## 30 Merrill Street

Fri, Oct 21, 2016 at 11:40 AM

1 FRONT (EAST) ELEVATION
SCALE: 1/4" = 1'-0"

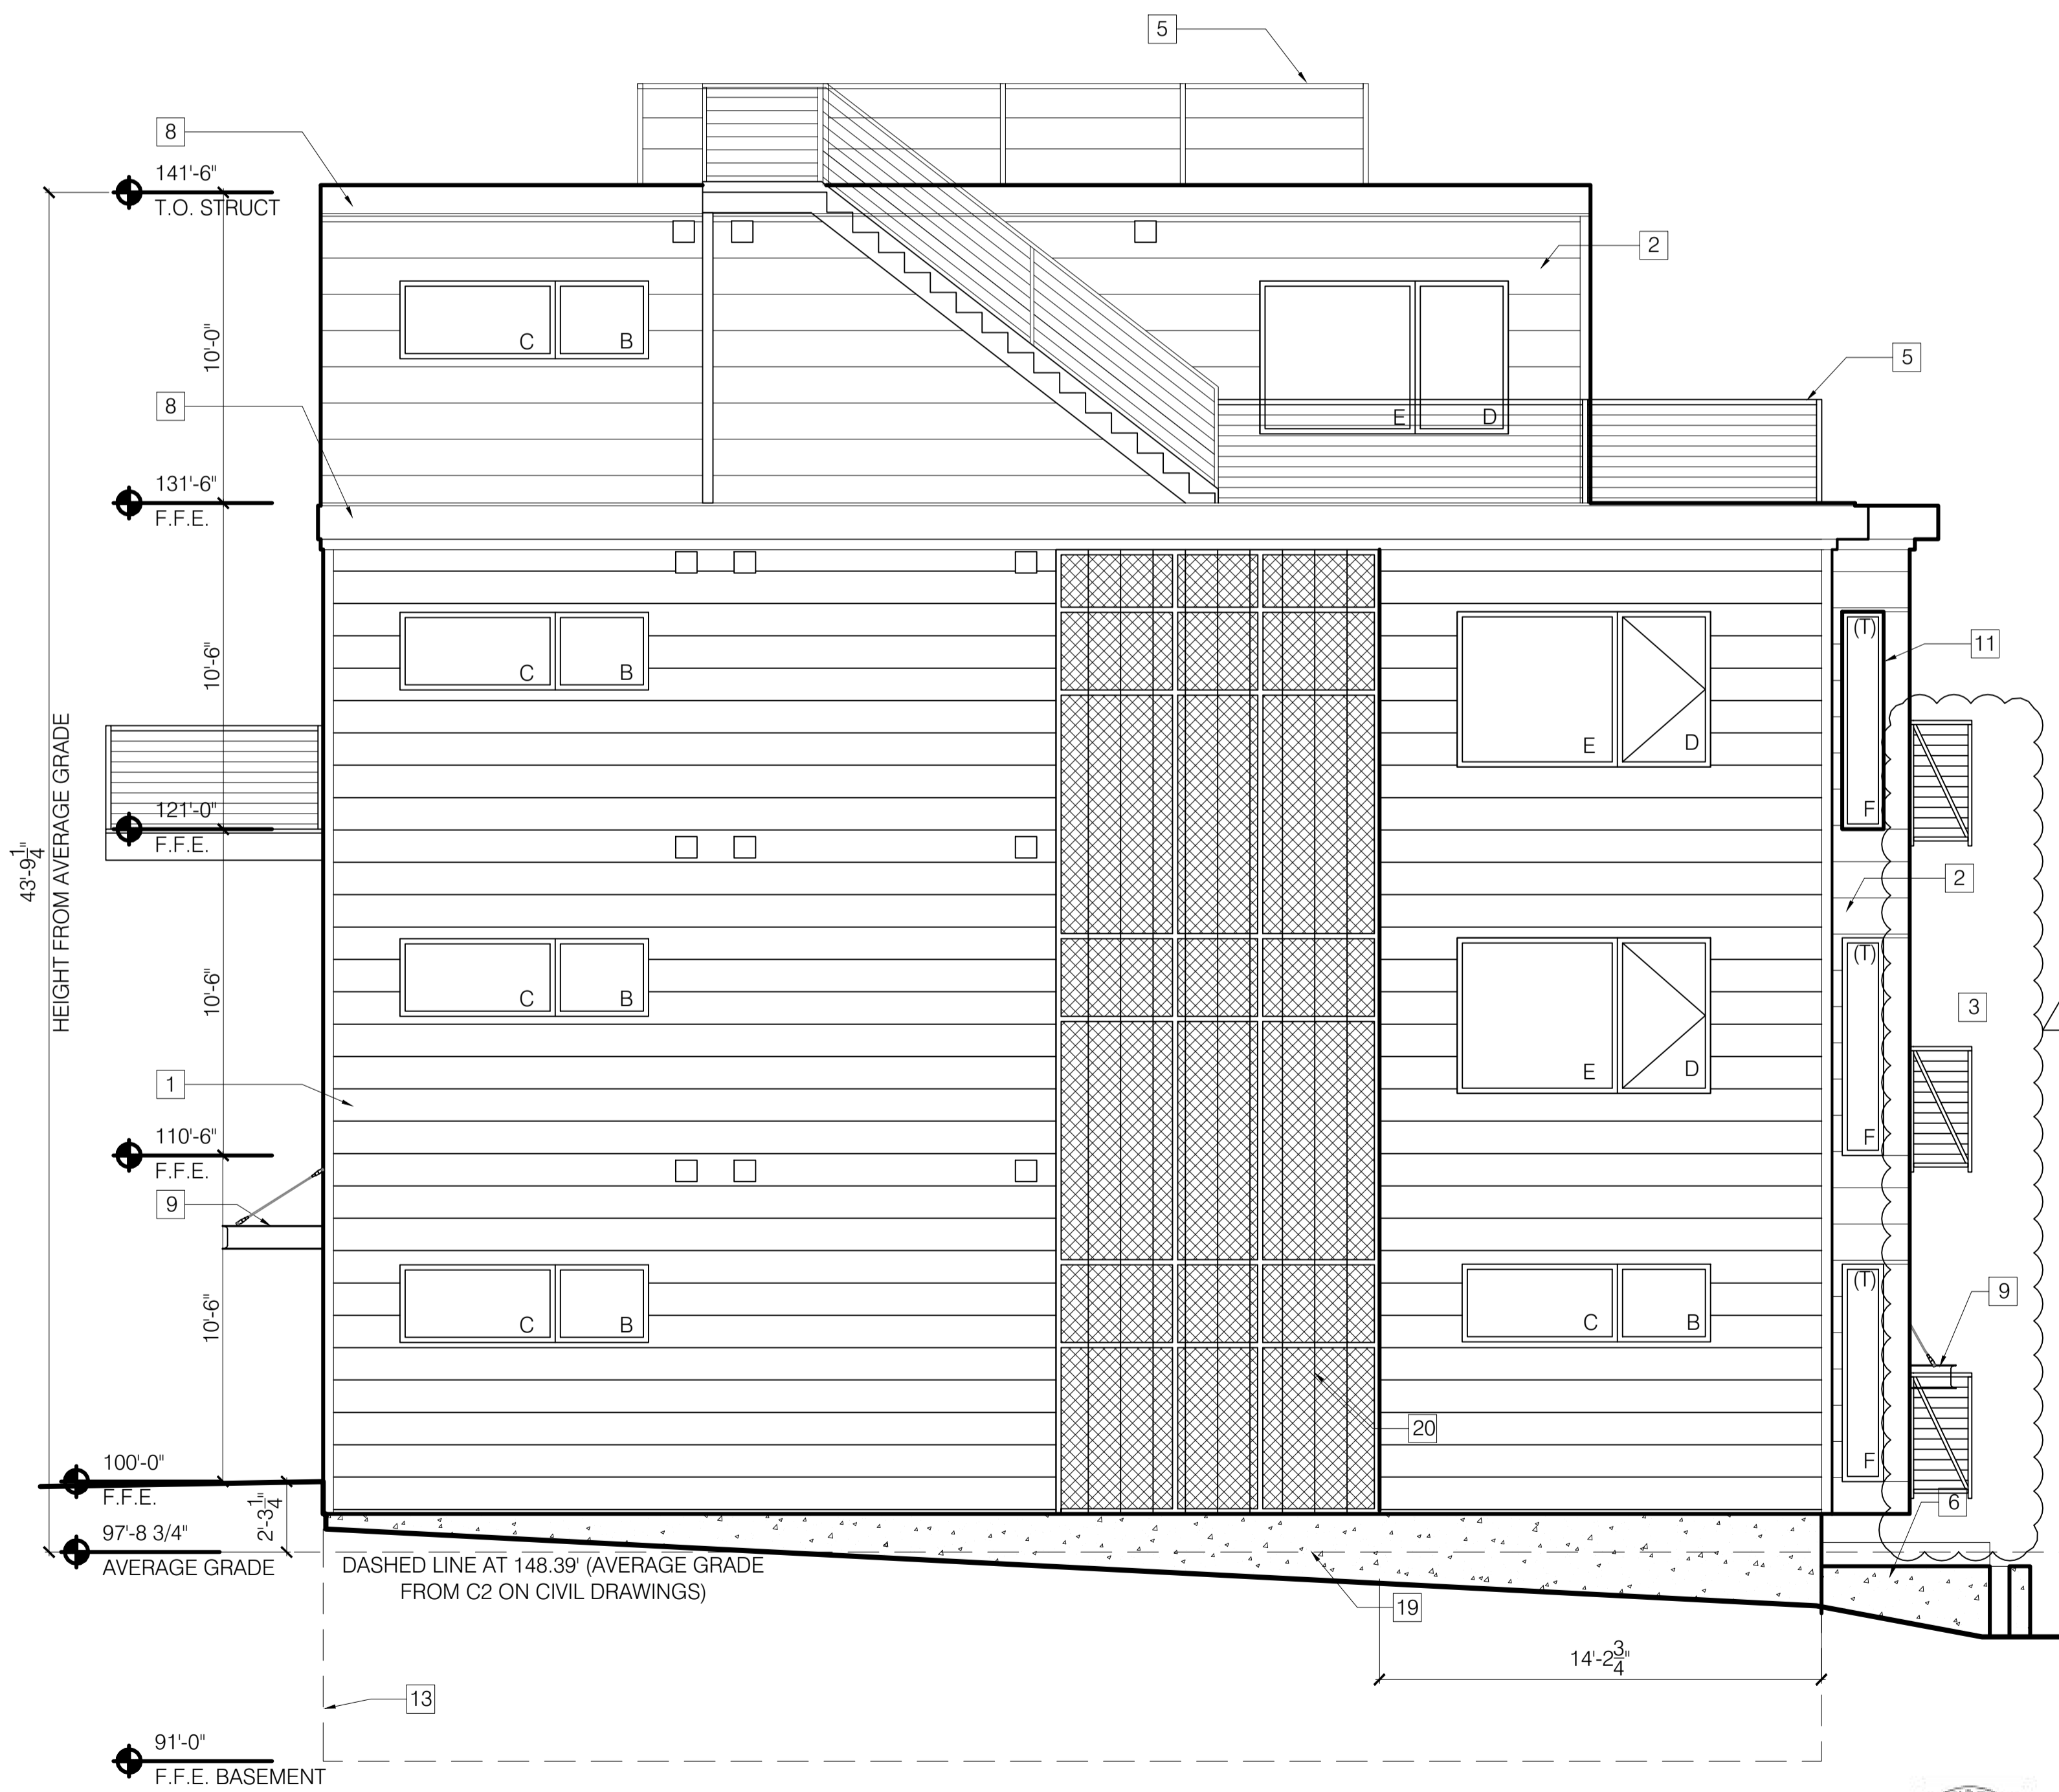
I'd like the architect to consider reversing the color scheme of dark and light grey (white?) on the front of the building, choosing the darker grey (now used in the cornice and side trim) for the bumpouts and the lighter color for the trim. This will make the stark contrast between the sides (around the larger windows) and the middle area less jarring and more in keeping with the look of the neighborhood.

Despite cosmetic reconfiguration, the front door still doesn't function as one. We've talked about the good reasons for the long-standing practice of main entrances in front, e.g., resident safety and organic interaction between neighbors. While I haven't seen the interior design, a neighbor has brought up another kind of safety issue: the possibility of police or the fire department automatically assuming that the front door leads to dwelling units, when it does not. Beyond that: the embarrassment for all residents, even those with street-facing units, who will have to instruct every guest to "come around the back". Not nice.
